Recommendation Report for Planning Permission for Works or Extension to a Dwelling

REF NO: AW/99/21/HH

LOCATION: 24 A'Becket's Avenue
Aldwick
PO21 4LX

PROPOSAL: First floor dormer extensions and alterations.

PROPOSED FIRST FLOOR PLAN

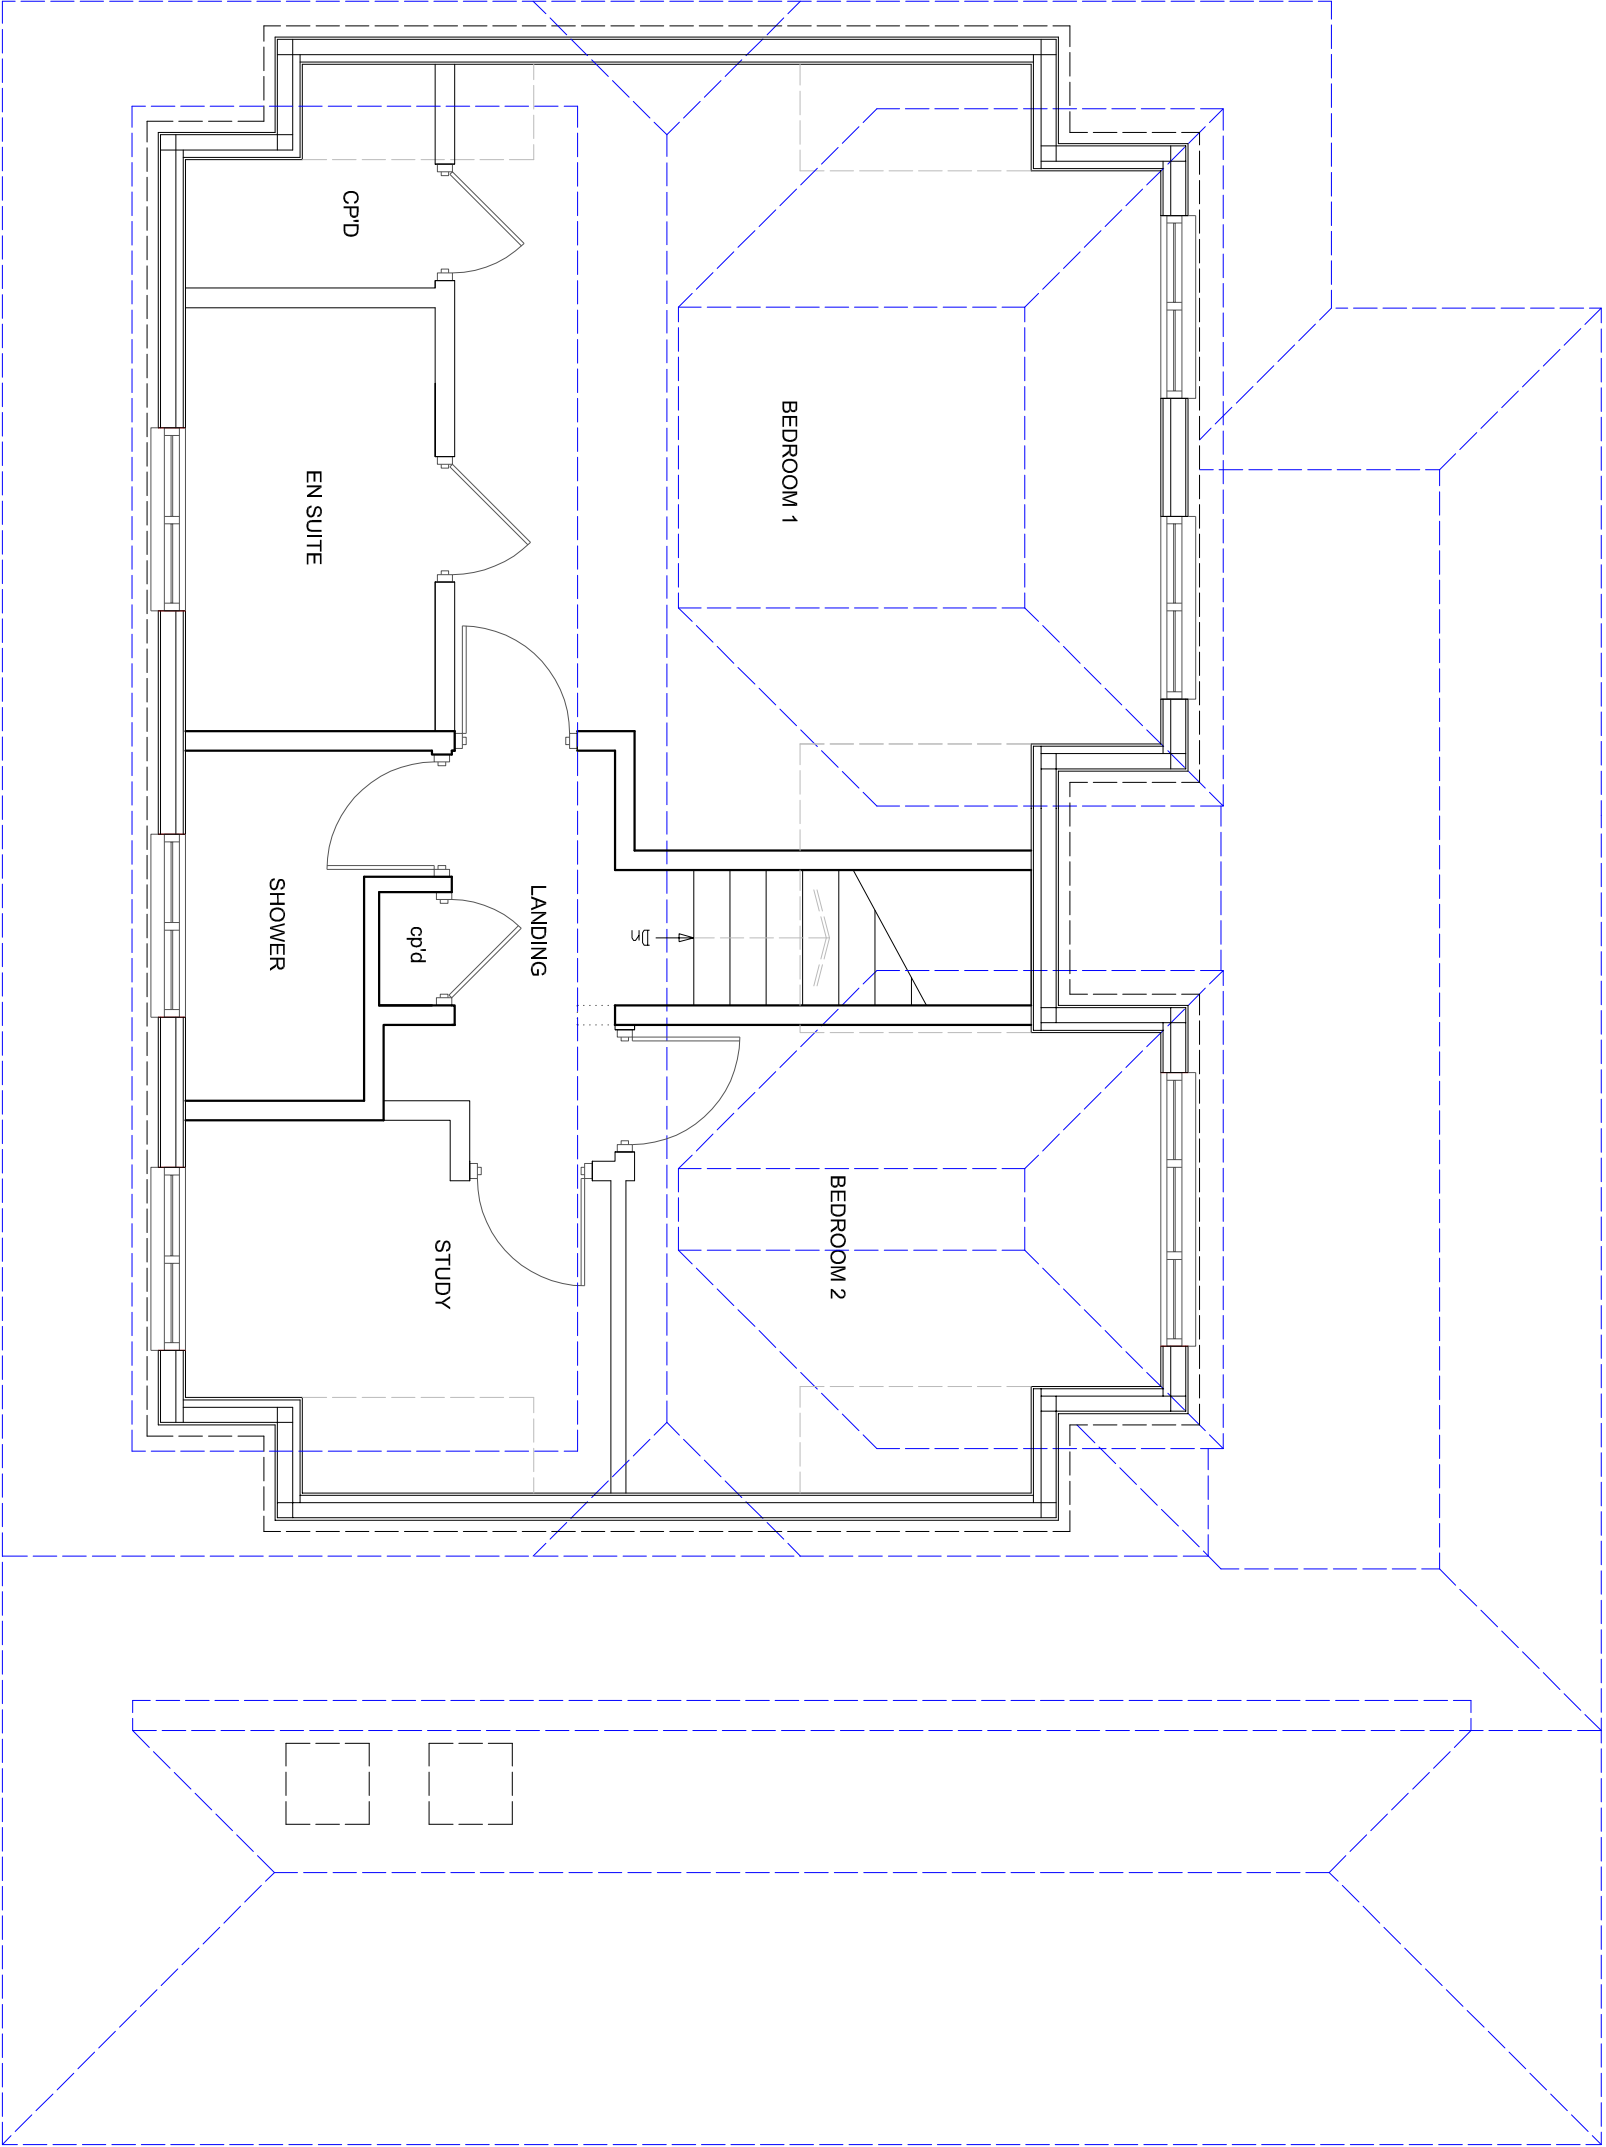
The dormers are located well away from any neighboring properties and are not considered to generate any additional overlooking, loss of light to or overbearing impact upon any neighbouring properties.

PROPOSED ELEVATIONS

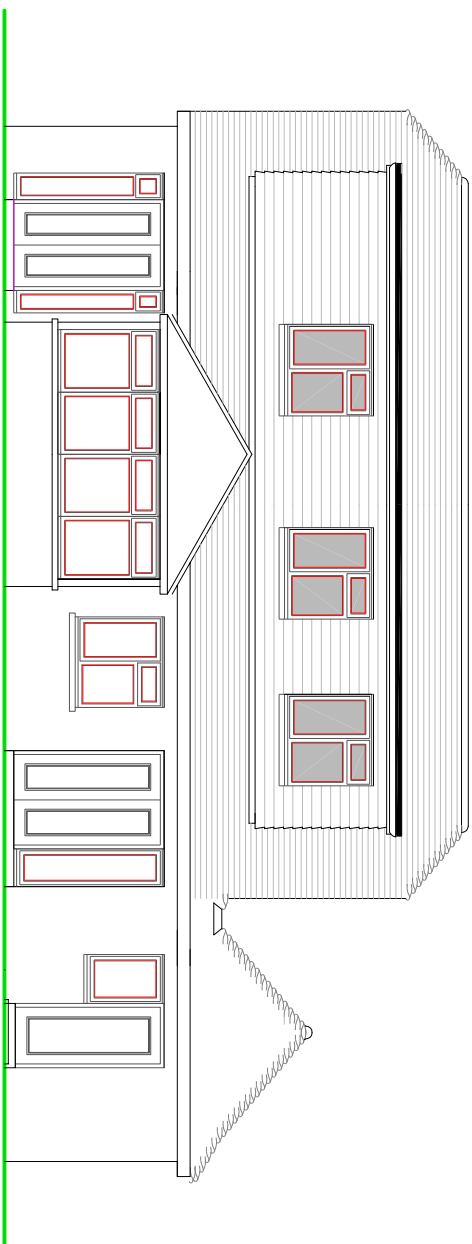
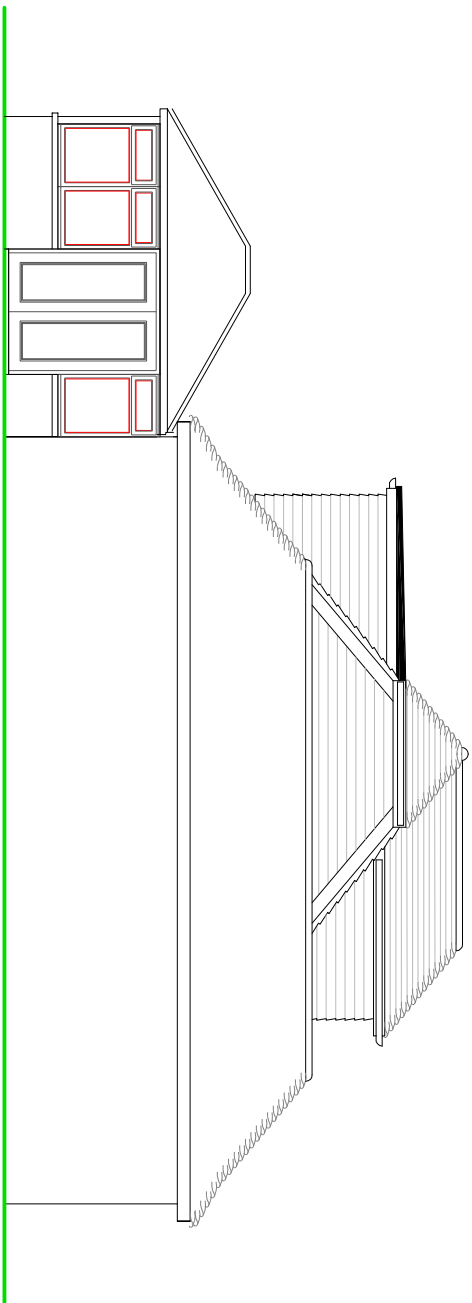
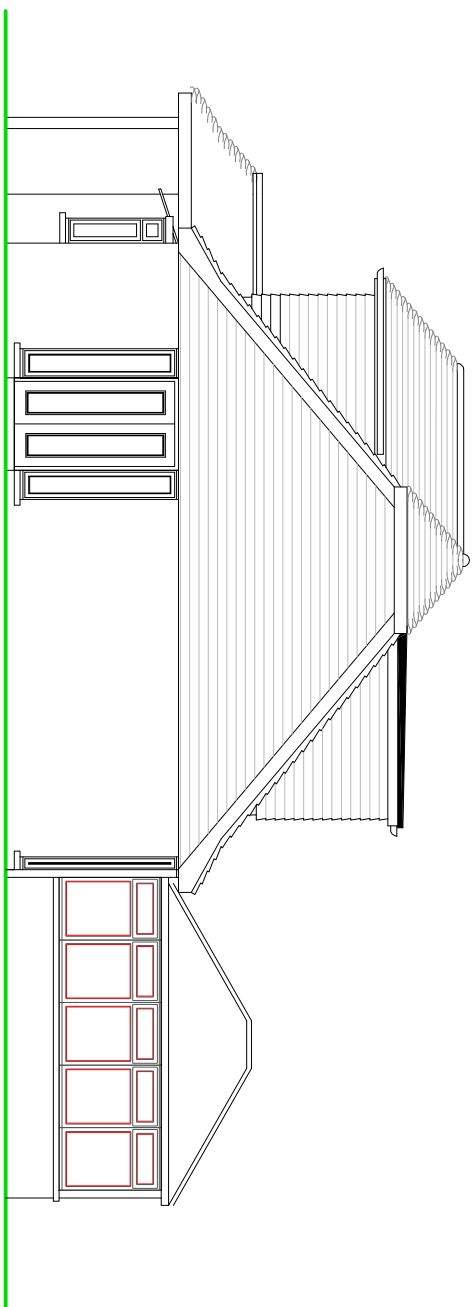
The design of the dormers is fairly conventional and are subservient to the existing dwelling house. They are in character with the existing dwellinghouse and the surrounding area..

The front dormers will have a significant impact on the street scene however the house is set well back on the plot which means the development has a minimal impact on visual amenity and an acceptable effect on the character of the area.

Arun recently adopted a Design Guide which provides detailed guidance that will help raise design standards across the District. Section M refers to householder extensions. The scale, massing and positioning of extensions should be visually subservient to the existing property. It is considered the proposal complies with the Design Guide as the development appears in modest in scale to the host dwelling. In addition the design guide states dormers are meant to be located centrally and symmetrically on the roof and minimise interference to the original form appearance and fabric of the original built structure which these proposed dormers comply with. The dormers are well balanced on the roof scape

On the south side of the dwelling the rear dormers will face down the garden with just an oblique view toward the side elevation of the neighbouring dwellinghouse which is not considered to cause a loss of residential amenity.

On the north side of the dwelling at the rear the dormers are separated by at least 5 metres from the boundary and look up the garden with an oblique view of the side elevation of the neighbouring property such that no adverse overlooking would occur.

At the front the building line of the applicants dwelling is forward of the neighbouring properties building lines such that no adverse overlooking from the dormer windows would occur.
